RE: SSD-9726 – ROYAL HALL OF INDUSTRIES - RESPONSE TO REQUEST FOR FURTHER INFORMATION

Table 1 Response to RFI

SWEPT PATH ASSESSMENT

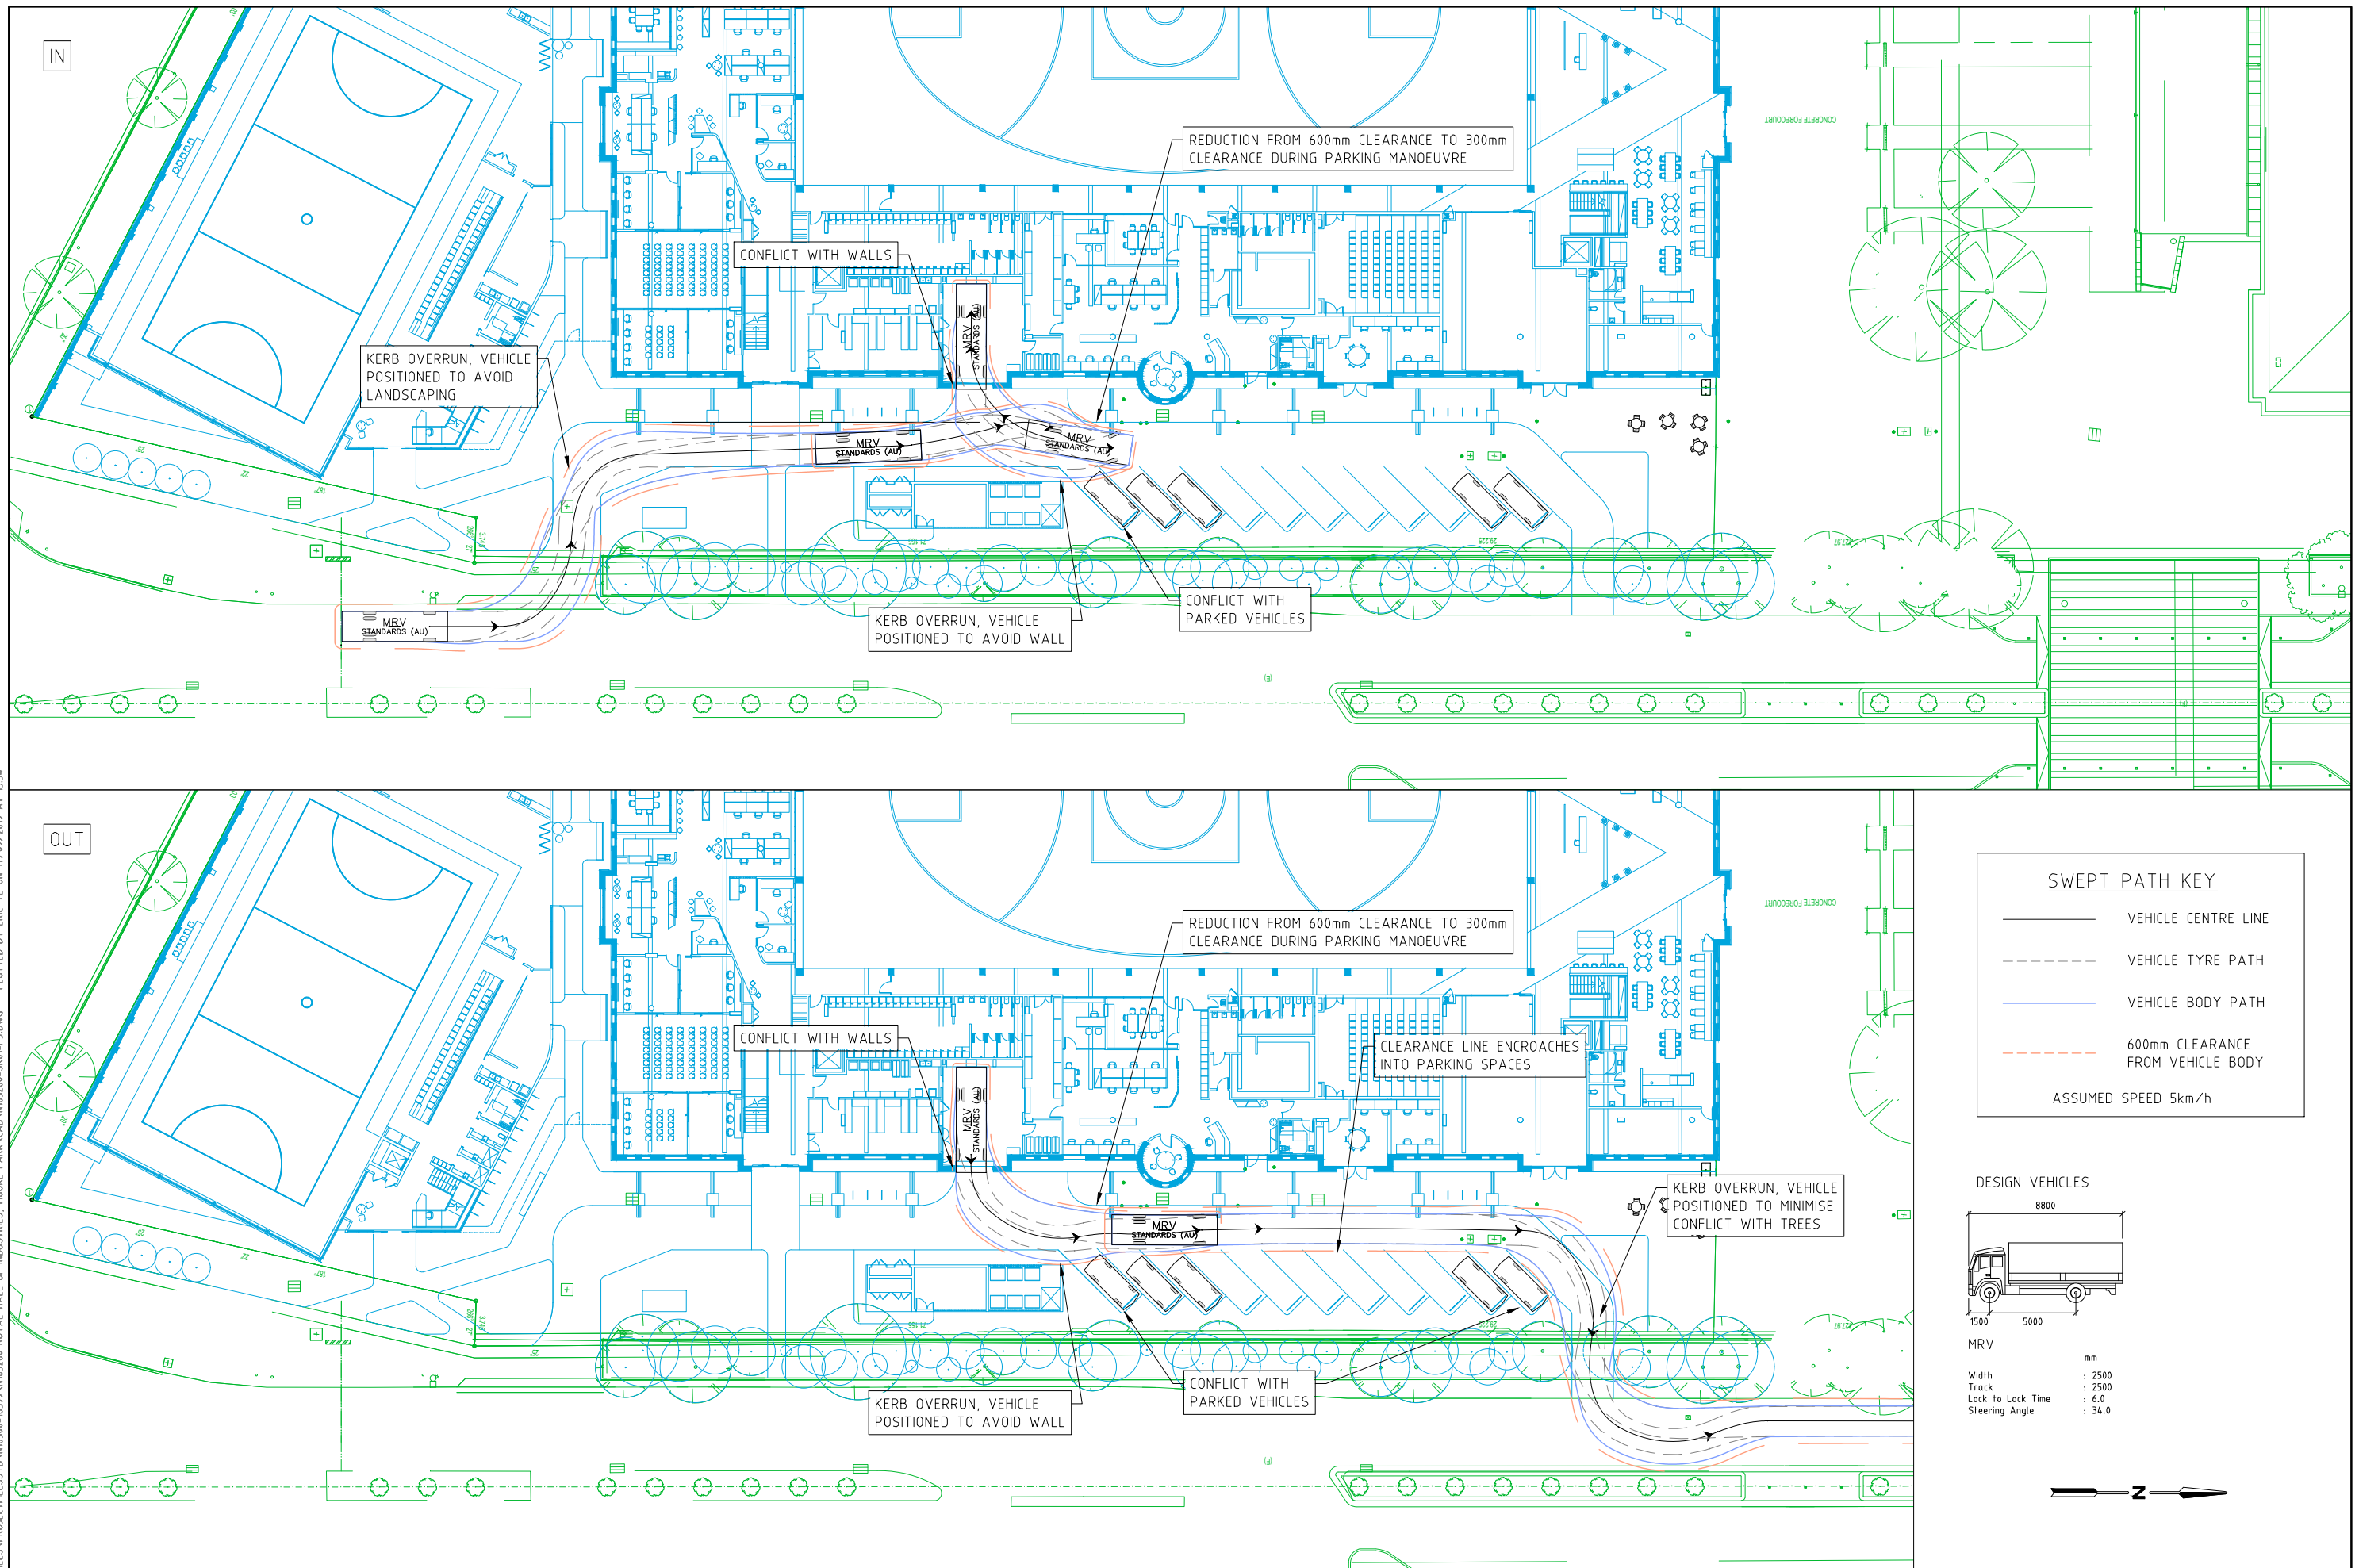
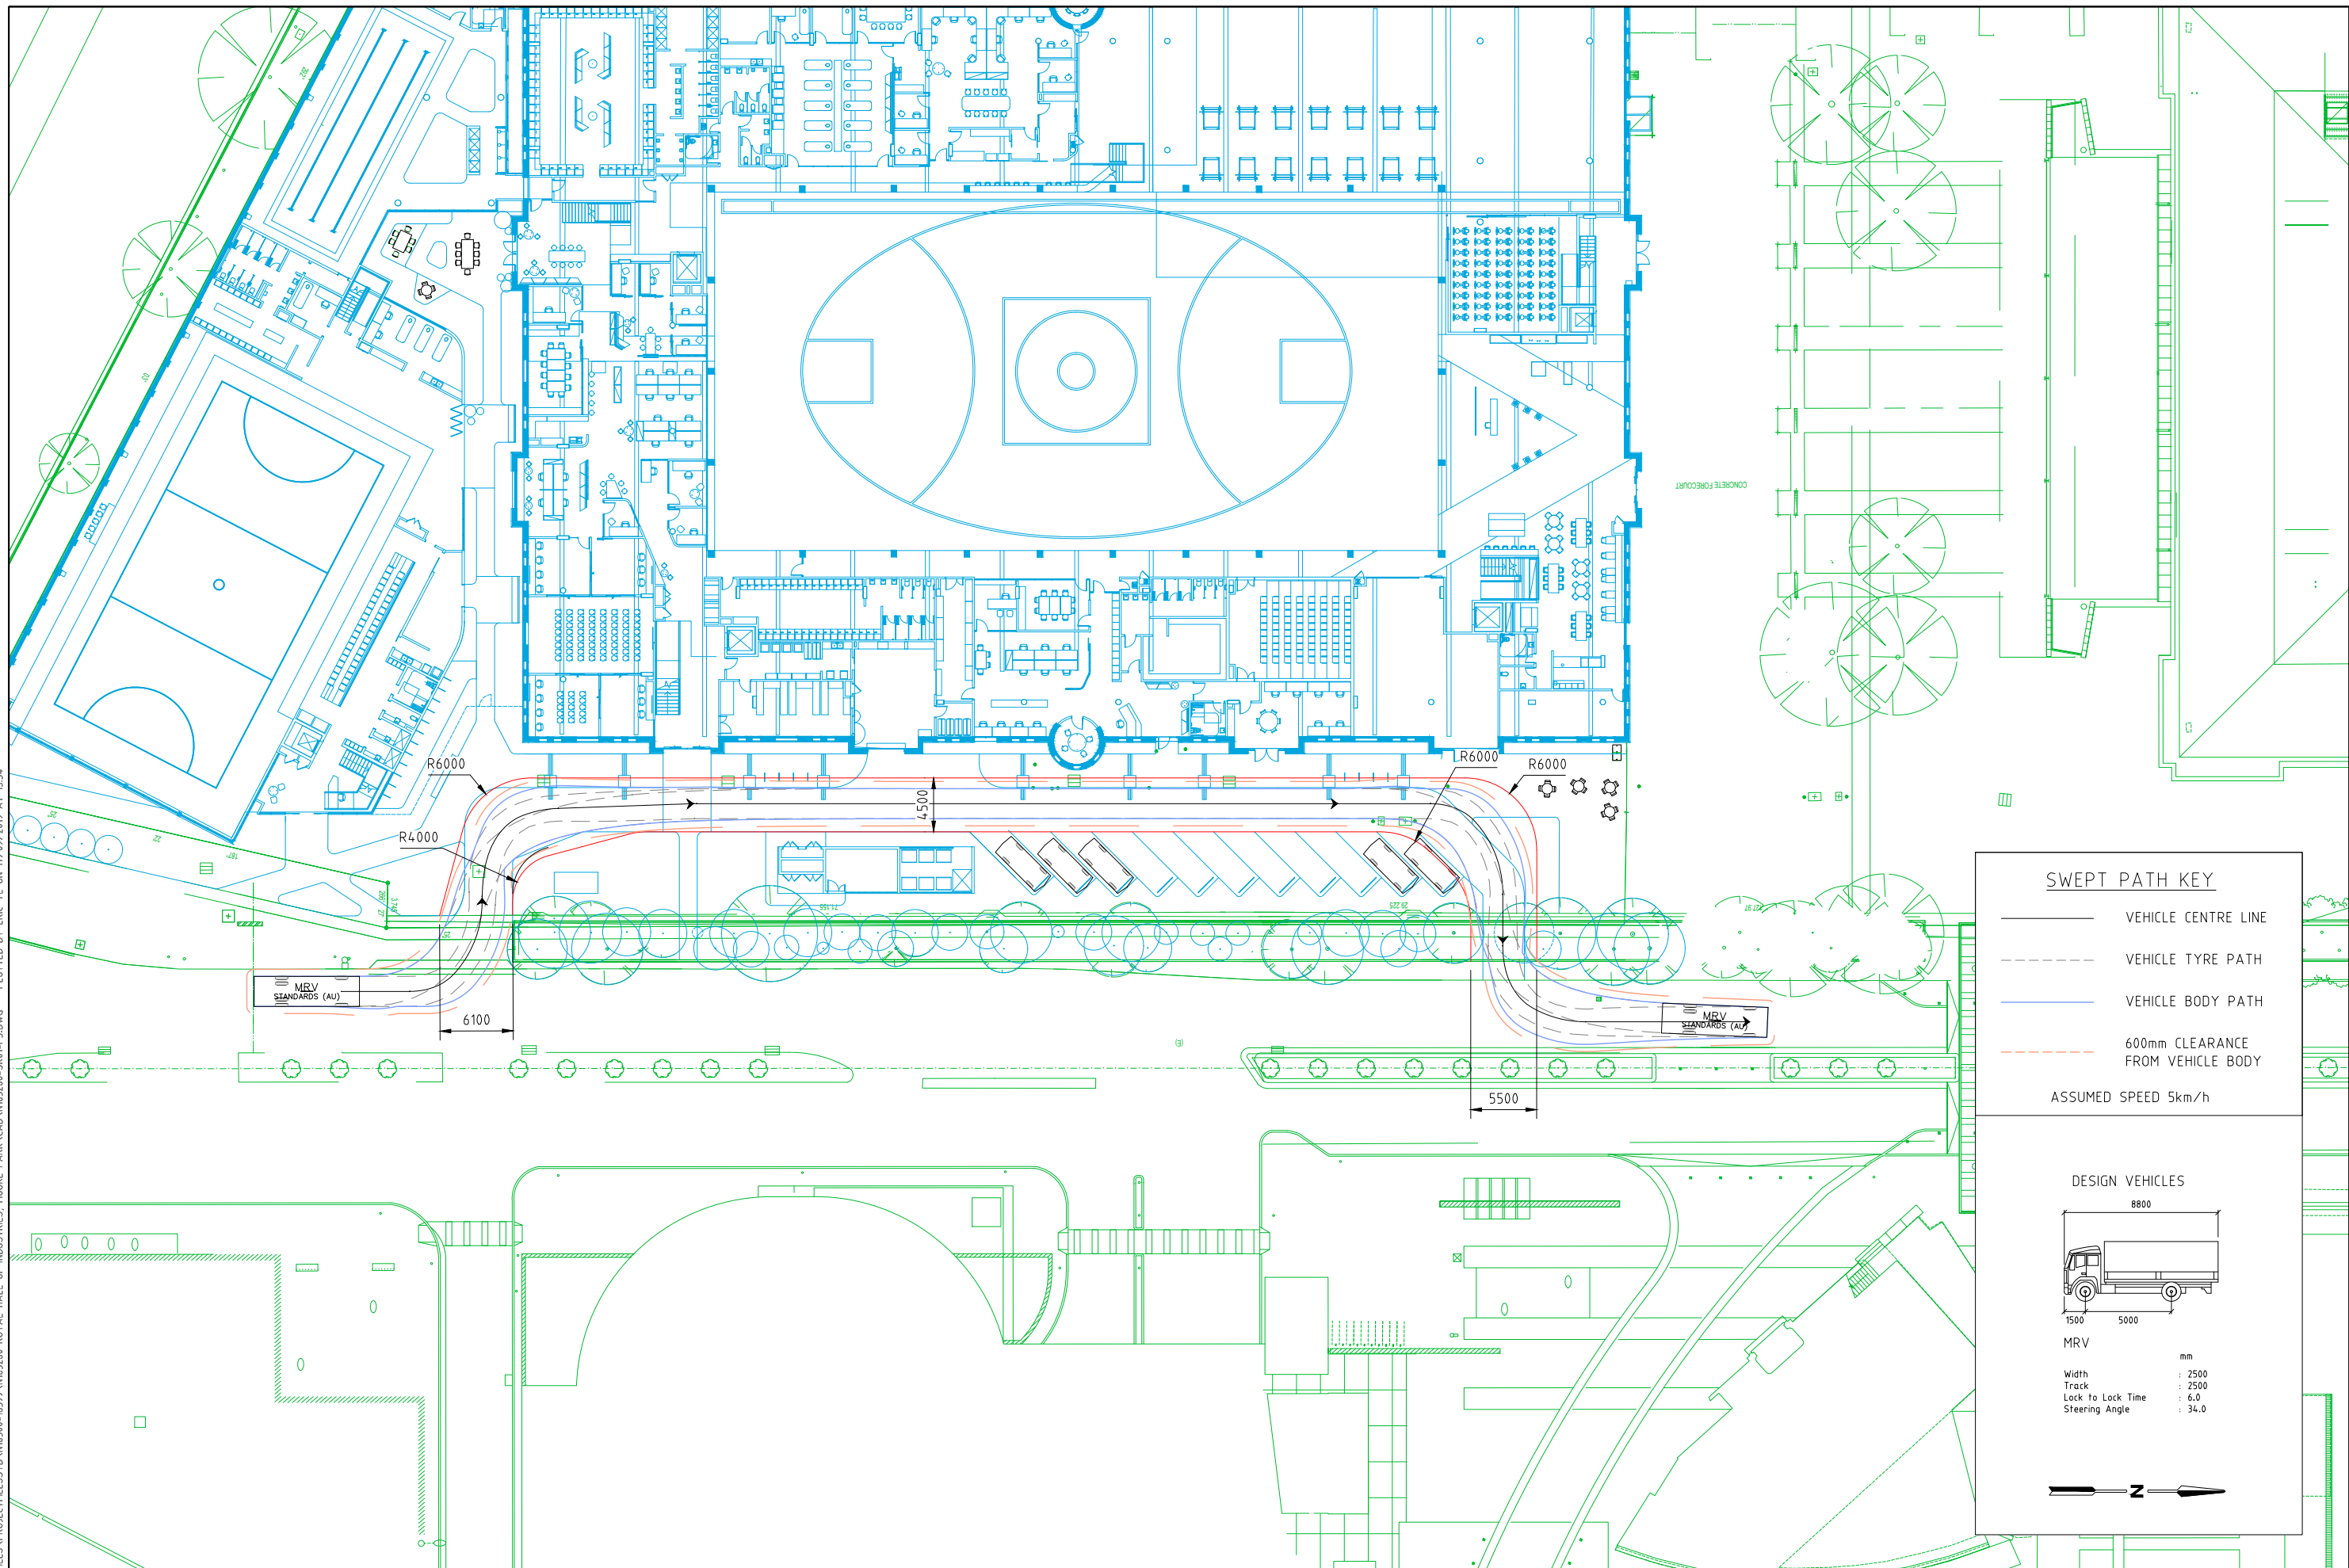
City of Sydney Comments	Proponent Response
	Swept Paths – Updated Swept Paths have been prepared by GTA and are provided at Attachment A .
<i>Public Domain</i>	N/A
<i>Landscape and Tree Management</i>	<p>The CoS submission states that the required information for trees 22, 36, 56 and 61 were omitted from the documentation. Analysis of these trees was undertaken in the initial Arboricultural Report (Reference D3355) submitted in the SSDA package in June 2019, and the Arborist Addendum prepared by Allied Tree Consulting (Reference 3355A) submitted in the Response to Submissions package in November 2019. For consistency, the table at Attachment B outlines the referenced trees, the project impact and the required tree protection measure.</p> <p>Further, it is suggested that the proposed pruning to trees 8 & 9 are conditioned to be dealt with separately through the ‘Limit on Consent’ condition.</p> <p>Discussion of the impact of the project on Trees 8 and 9 is discussed in the Arboricultural Report (Reference D3355) submitted in the SSDA package in June 2019, and the Arborist Addendum prepared by Allied Tree Consulting (Reference 3355A) submitted in the Response to Submissions package in November 2019.</p> <p>The ground floor of the proposed NSB will conflict with the low-hanging branches of Trees 8 and 9 which extend over the heritage wall and into the site, as illustrated in Figure 1. The height of the NSB ground floor exceeds the height of the tree dripline, and as such pruning will be required to enable the construction of the building and the ongoing health of the trees. Whilst it is acknowledged that Level 1 of the NSB will not conflict with the tree dripline due to the setback, the dripline will encroach into the Ground Level roofline.</p>
